43 Brookmans Avenue
Hatfield
Herts
AL9 7QH
29th September 2018

RE: 77 Brookmans Avenue, 6/2018/1996/FULL Erection of 8 x self-contained apartments with lower ground floor car park following demolition of existing dwelling

We wish to object to the planning proposal at 77 Brookmans Avenue on four grounds, Character and Context, Unduly Dominant Mass, Parking Provision and Planning Obligations.

Right Side Elevation (Side Wall)
As Proposed - Scale 1:100

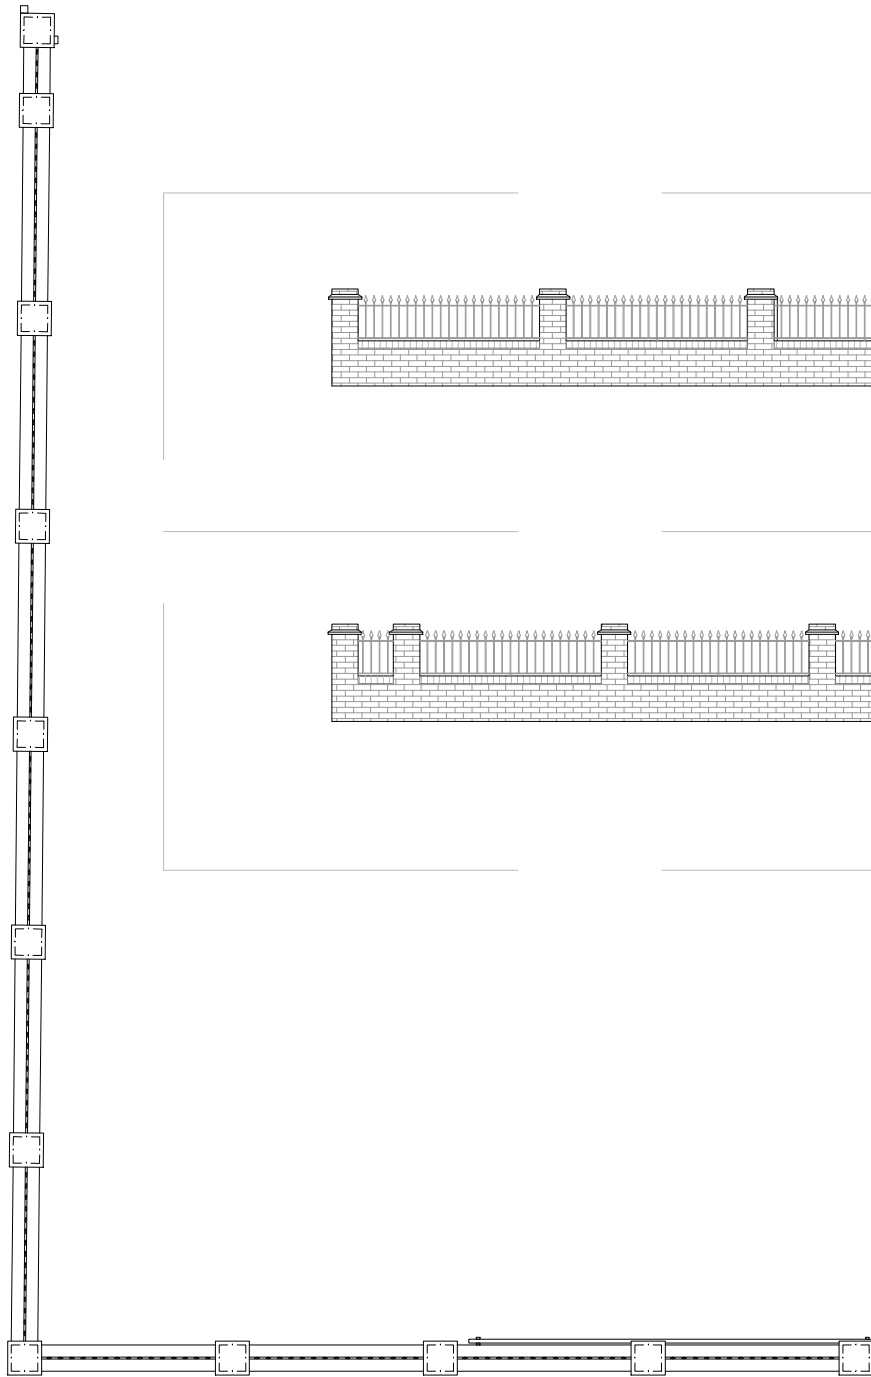
The huge increase in footprint extending back significantly from the existing property and beyond those adjacent, despite some of it being single story, will clearly have an overbearing feel, rather like being next to a small warehouse, for both 79 Brookmans Avenue and in particular 75 Brookmans Avenue. A significantly reduced footprint could address this issue, but until then the proposal should be rejected.
